OXFORDSHIRE COUNTY COUNCIL'S RESPONSE TO CONSULTATION ON THE FOLLOWING DEVELOPMENT PROPOSAL

Application no: 14/01932/OUT

Location: OS Parcel 7400 adjoining and South of Salt Way, Banbury

Transport

Figure 14 - Development Framework Plan

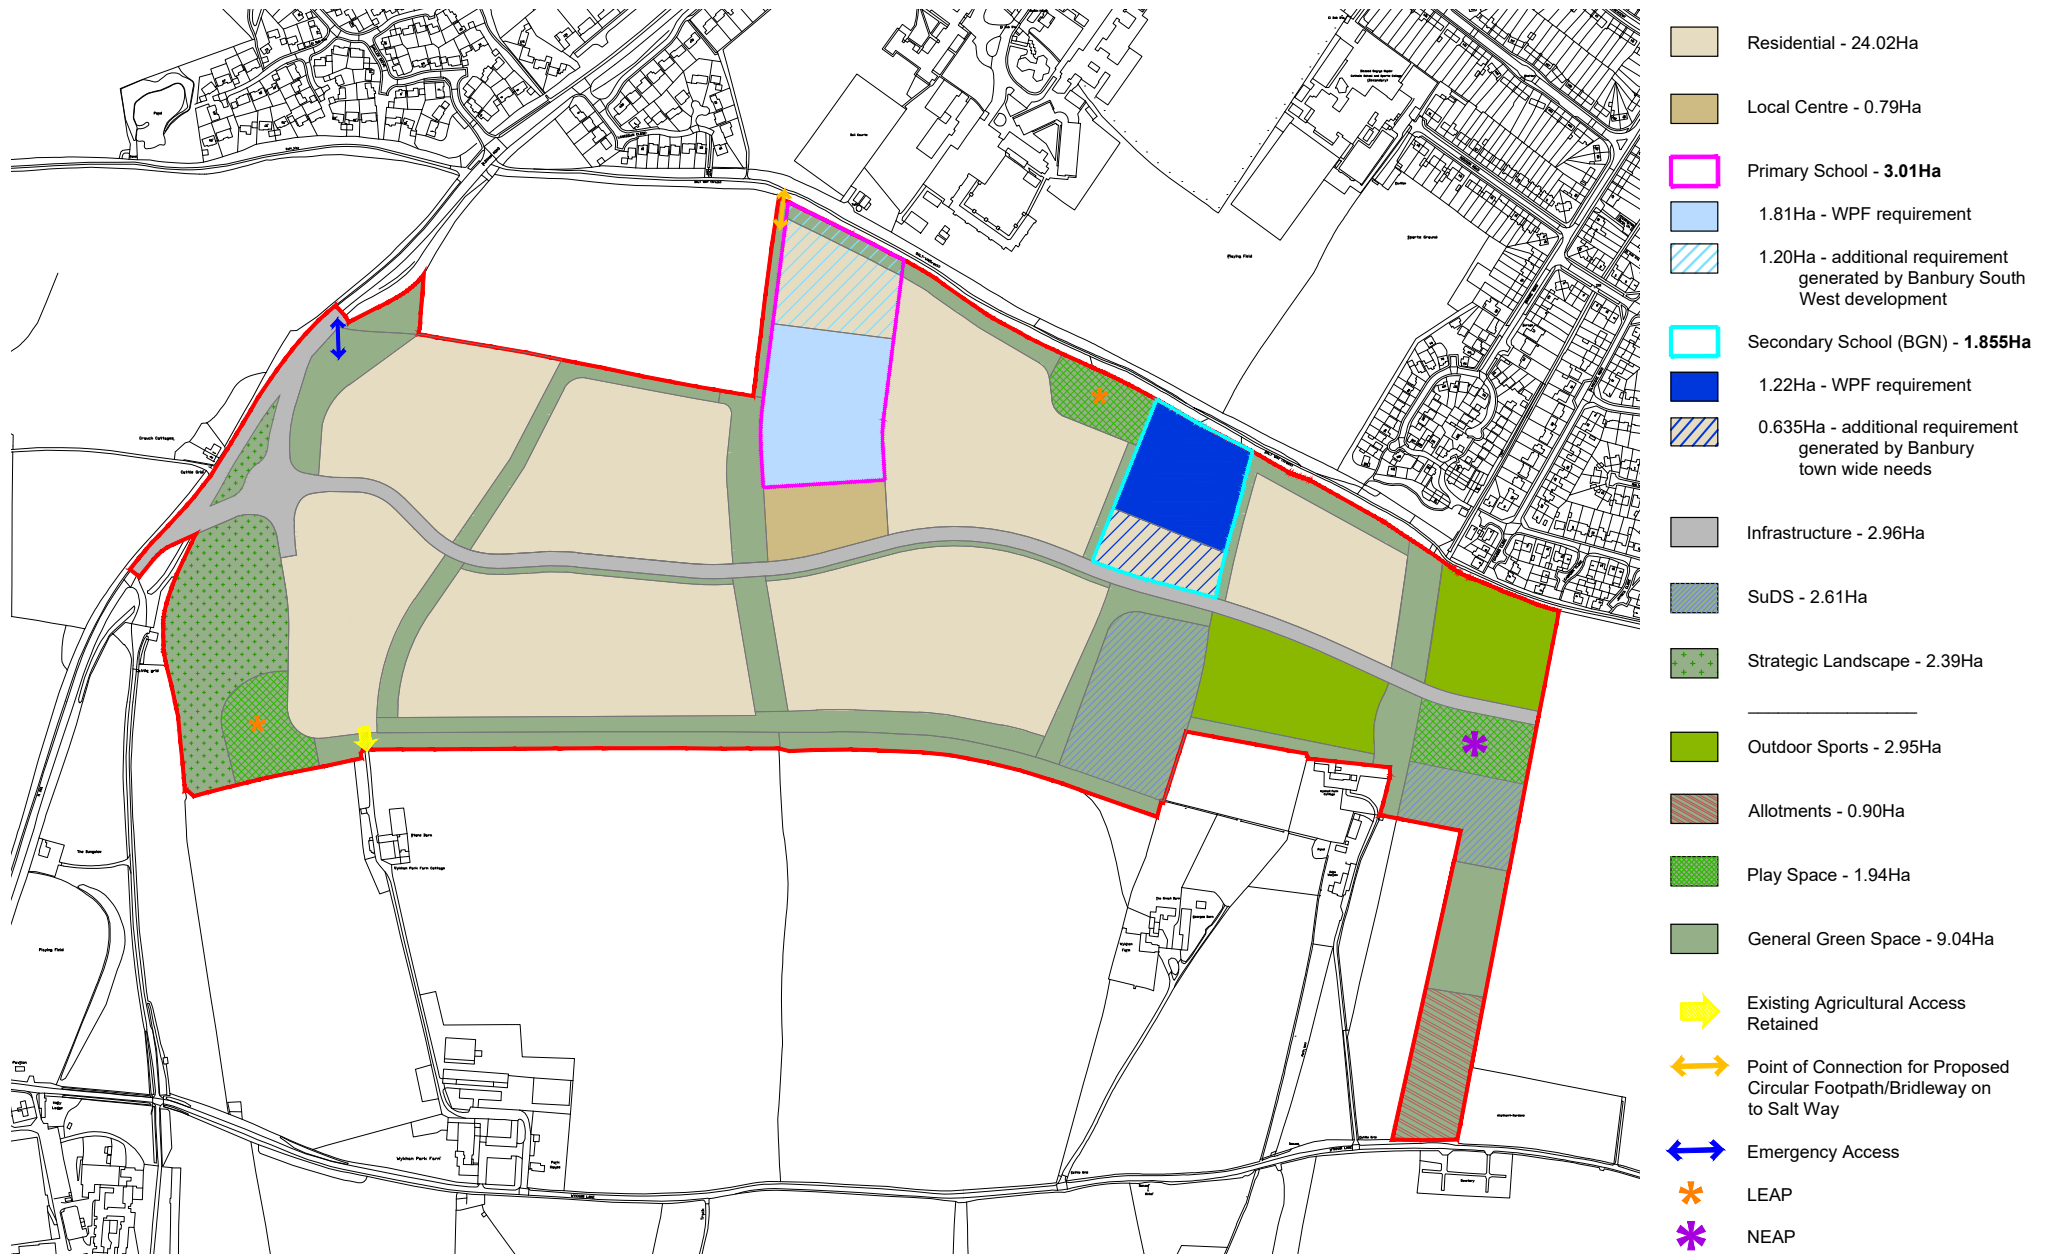
The Development Framework Plan submitted, whilst acknowledging that the North West corner of Banbury 17 has planning permission, does not integrate with this development for which the detailed site layout has been permitted through the reserve matters process (14/01225/REM). It is essential that all land parcels forming Banbury 17 integrate to form a cohesive development. Transport links to the North West parcel should form part of this application, however these are omitted.

Figure 20 – Movement Network

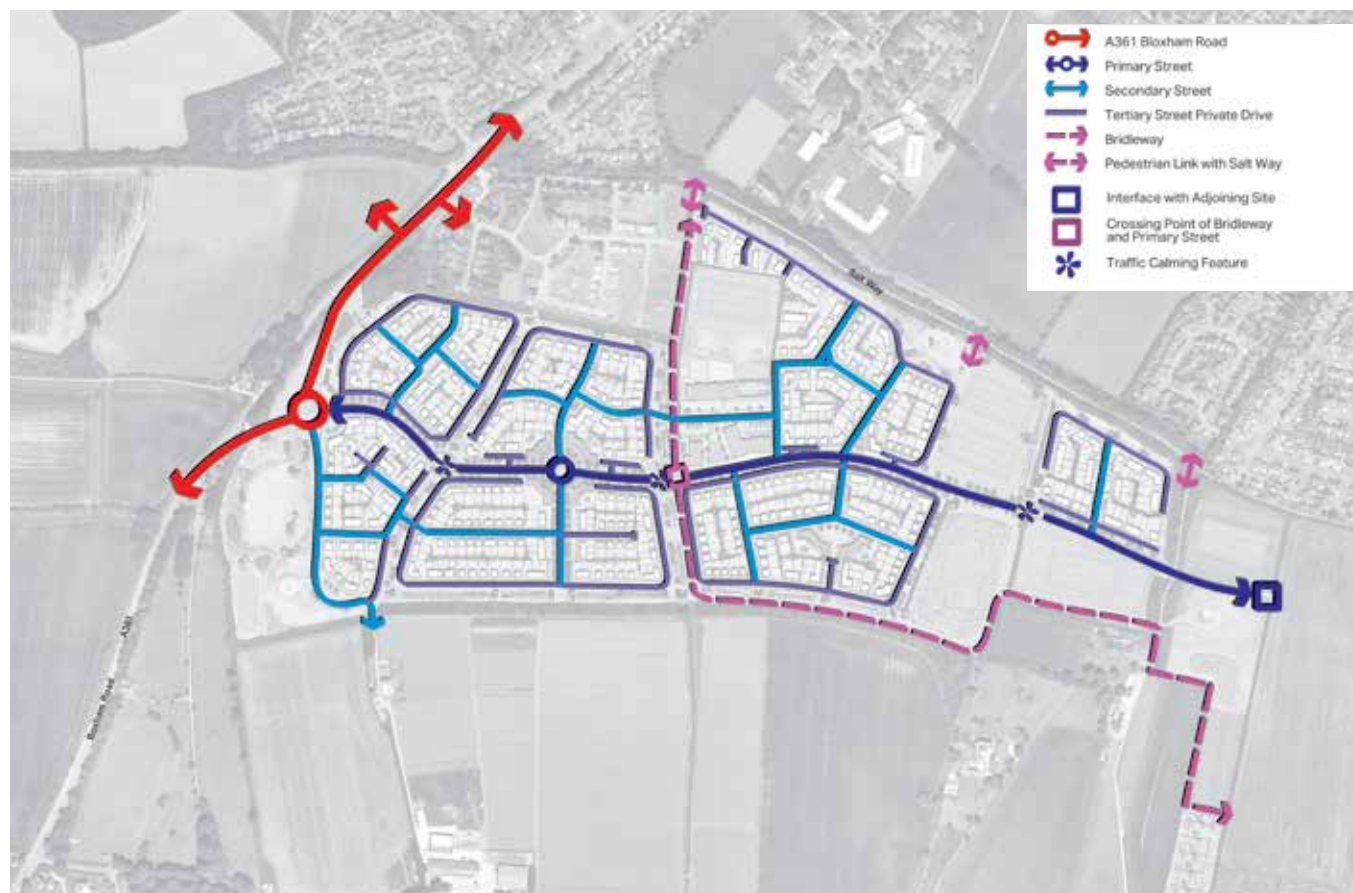
The Design & Access statement provides an indicative movement strategy (figure 20) including ‘potential new footpath connections’ to access the development from the Salt Way restricted byway. The transport assessment states that three shared use cycle links will be provided from the site to the Salt Way, however does not define these.
